**RE: ST MATTHEW'S CATHOLIC SCHOOL, BROADHEAD & BRUCE RD, MUDGEE
BCA COMPLIANCE STATEMENT FOR DA SUBMISSION**

This statement has been prepared to verify that Blackett Maguire + Goldsmith Pty Ltd have undertaken a review of the architectural documentation that will accompany the State Significant Development Application to the Consent Authority for the proposed St Matthew's Secondary School against the Building Code of Australia 2019 (BCA).

**BLOCK B - GROUND LEVEL PLAN**  
1 : 100

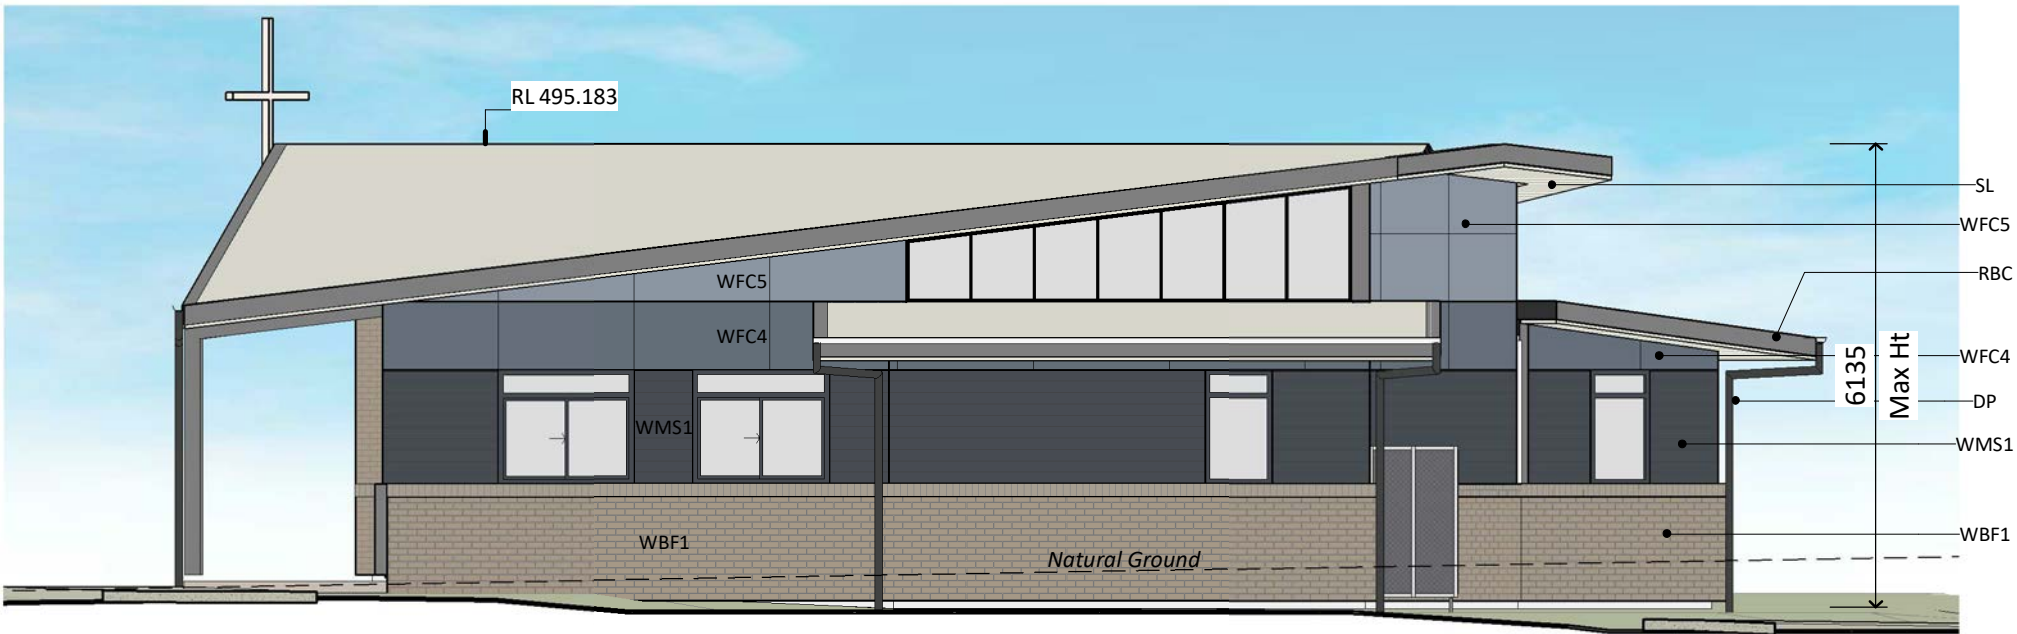
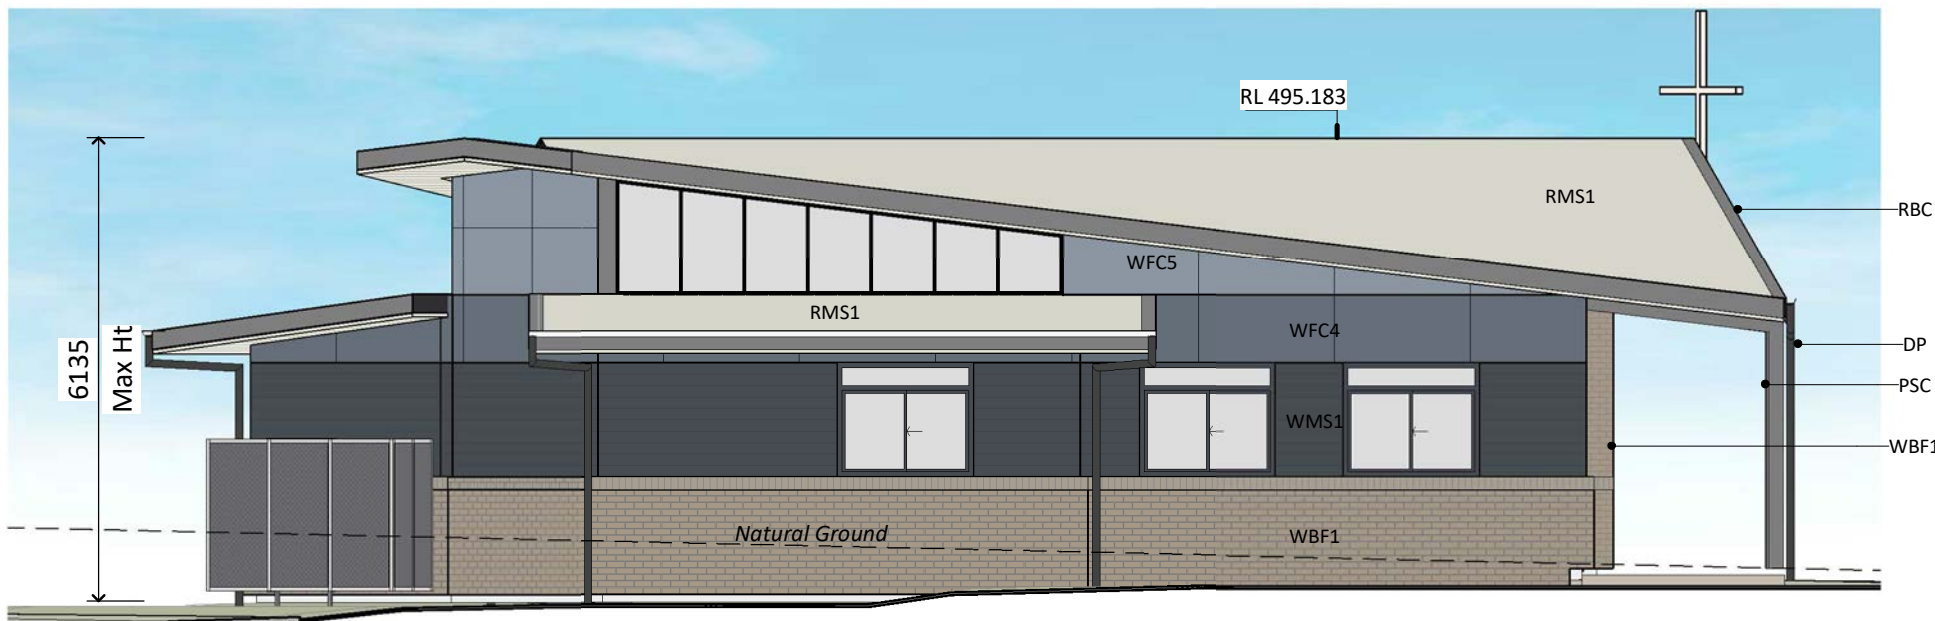
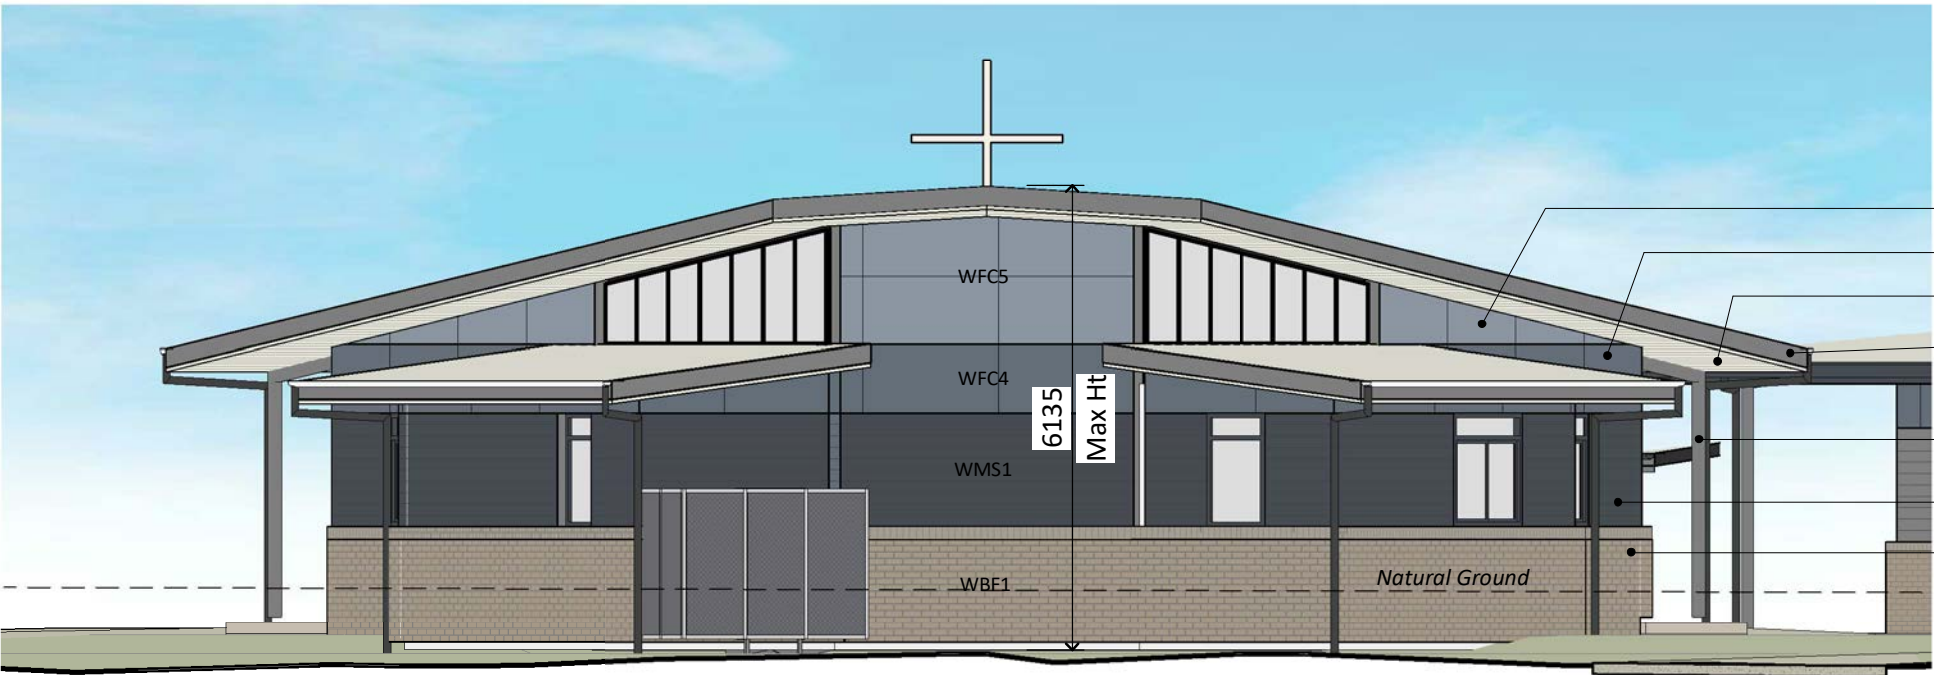
Block B population of 150 students – We understand that toilets will be relied upon in Block C.
